INNER WEST COUNCIL

6 April 2018

WESTCONNEX STAGE 3 (M4-M5 LINK) SUBMISSIONS & PREFERRED INFRASTRUCTURE REPORT (SPIR)

ATTACHMENT 1:
INNER WEST COUNCIL'S COMMENTS ON
WESTCONNEX STAGE 3 (M4-M5 LINK)
SUBMISSIONS & PREFERRED INFRASTRUCTURE REPORT
APRIL 2018

Figure 2-1 Indicative White Bay civil site (C11) layout

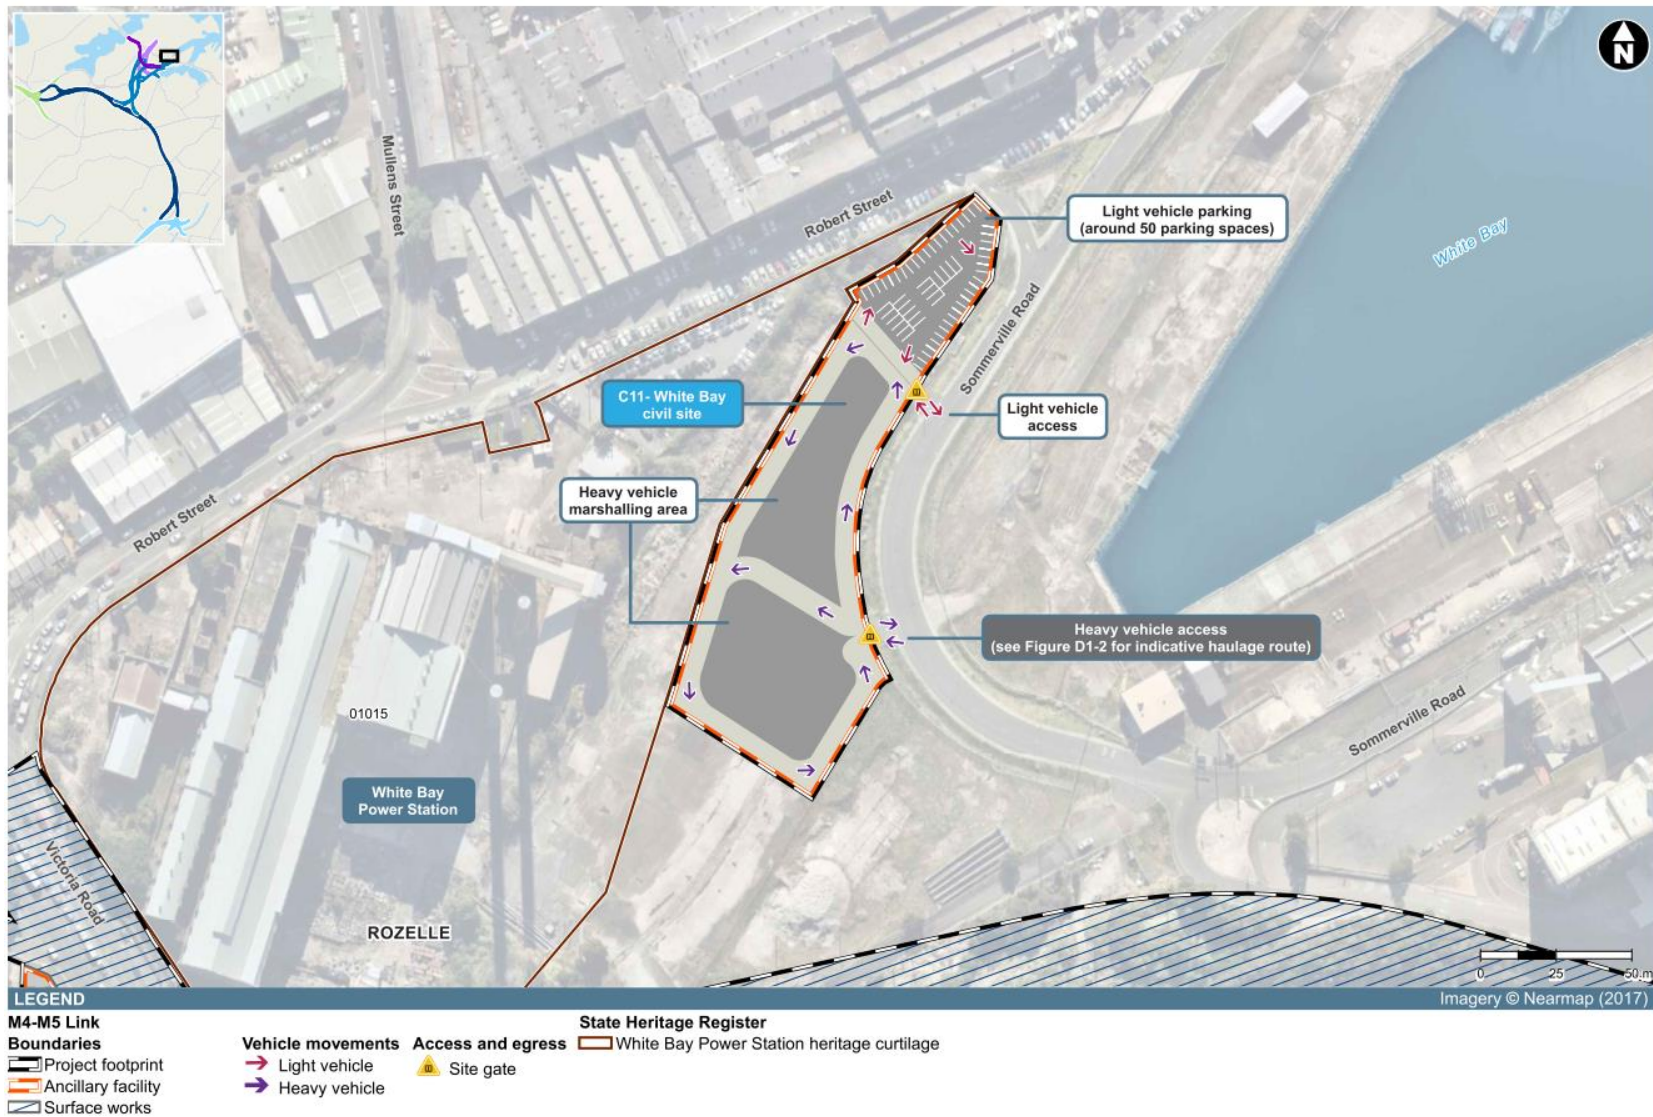
Council notes the SPIR proposes a truck marshalling and employee parking area at White Bay on land owned by the Port Authority of NSW, called the White Bay Civil Site (C11). In general terms, this is a positive addition to the proposal because it will provide for off-street marshalling in an area that would not directly affect local residents and businesses. This would avert use of streets for marshalling – which has been a negative feature of Stage 1. The site includes an employee car park, which should assist with minimising parking demands on surrounding local streets.

Figure 3-1 Indicative spoil haulage route – White Bay civil site (C11)

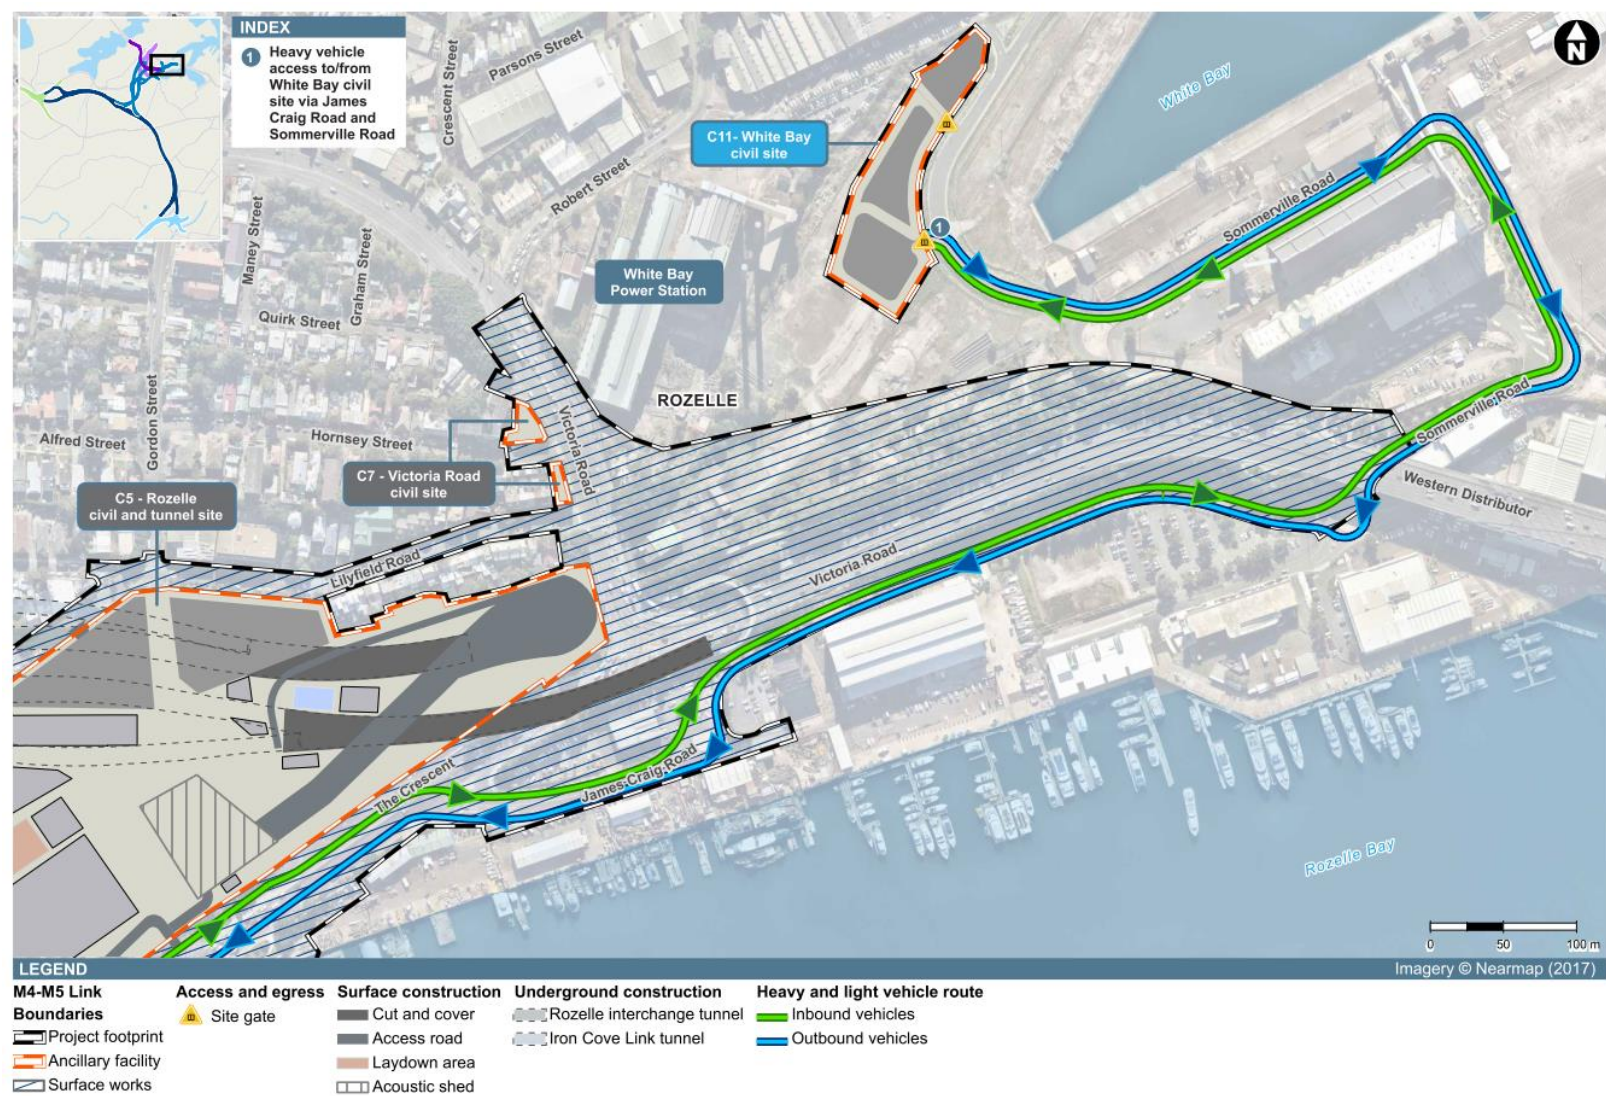
In the main, trucks would use main roads to/from the site – predominantly James Craig Road and City West Link Road, so there would not be a significant direct noise impact on residents near these roads. However, Council is concerned about the traffic congestion and road safety impacts of spoil trucks using all roads, including main roads. There would also be a cumulative truck traffic impact from other projects that would use the White Bay site and surrounding roads. These projects include the WHT, Glebe Island multi-use facility and concrete batching plant and possible spoil handling facility.

Congestion of the James Craig Road route may lead proponents of the above projects to seek to use of Robert Street as an alternative. Council is opposed to use of Robert Street as this street includes many small businesses, provides access to the passenger cruise terminal and is already congested. It has limited ability to carry additional traffic, particularly heavy vehicles.

Council is also concerned about the truck route between White Bay and the Pyrmont Bridge Road sites using Johnston Street, Annandale (southbound) as this street (albeit a State Road) is predominantly residential and includes schools, small businesses and a retail village. Spoil trucks travelling southbound from the White Bay marshalling site to the Pyrmont Bridge Road site would create noise impacts (particularly as trucks are empty) and potentially road safety impacts.

Figure 3-2 Indicative spoil haulage route – Darley Road civil and tunnel site (C4)

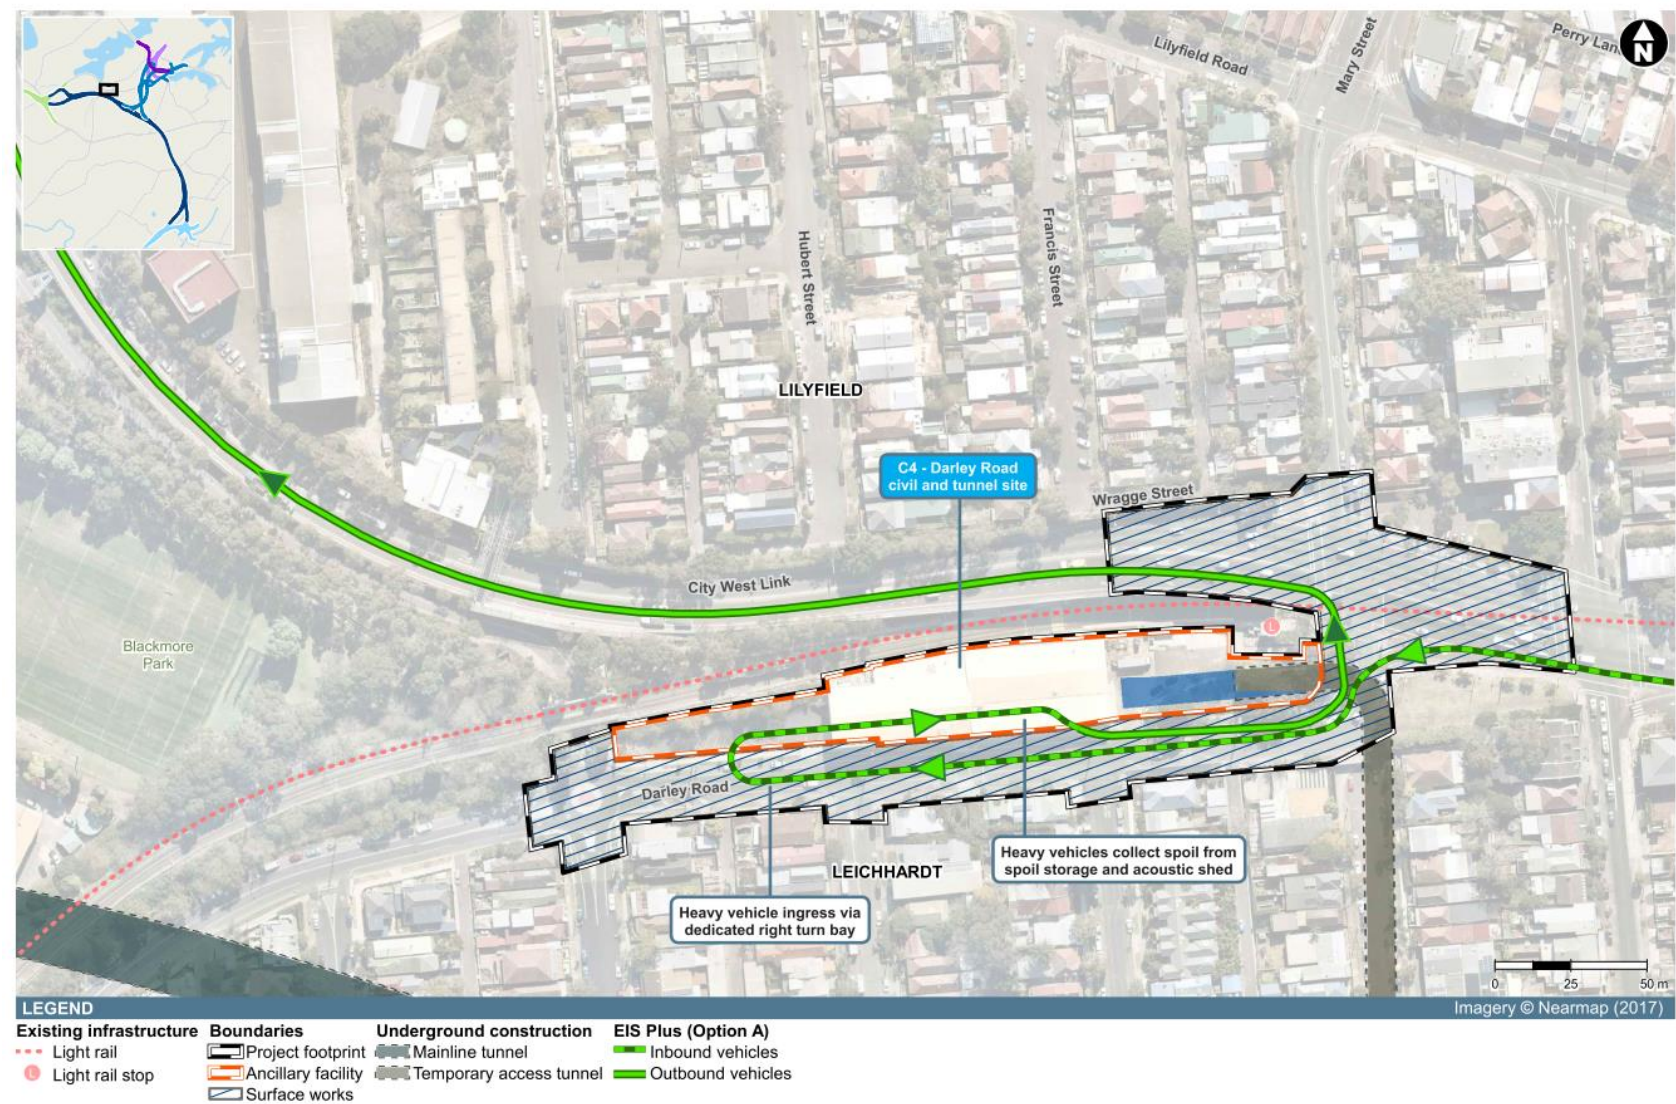
Council notes from the SPIR that trucks travelling from the White Bay marshalling site to Stage 3 construction sites on Parramatta Road at Ashfield would travel along City West Link Road, Darley Road, Foster, Tebbutt, Hathern, Brown and Cook Streets, Old Canterbury Road and Parramatta Road. Council is concerned about this route because all the streets between Darley Road and Parramatta Road are residential streets, and there is a primary school on Tebbutt Street. The left turn from Old Canterbury Road onto Parramatta Road

also raises traffic safety concerns, as it is likely that trucks would need to cross into the centre lane of Parramatta Road to negotiate this turn.

Regarding truck movements to the Darley Road site, Council notes that establishment of the White Bay marshalling area would result in a slight improvement to the efficacy of truck movements to/from that site by allowing trucks to enter the City West Link / Darley Road intersection from the east instead (left turn in) of the west (right turn in). Notwithstanding, Council remains concerned about use of that intersection by project trucks, just as it remains concerned about noise, dust and parking impacts on residents from the Darley Road operation.
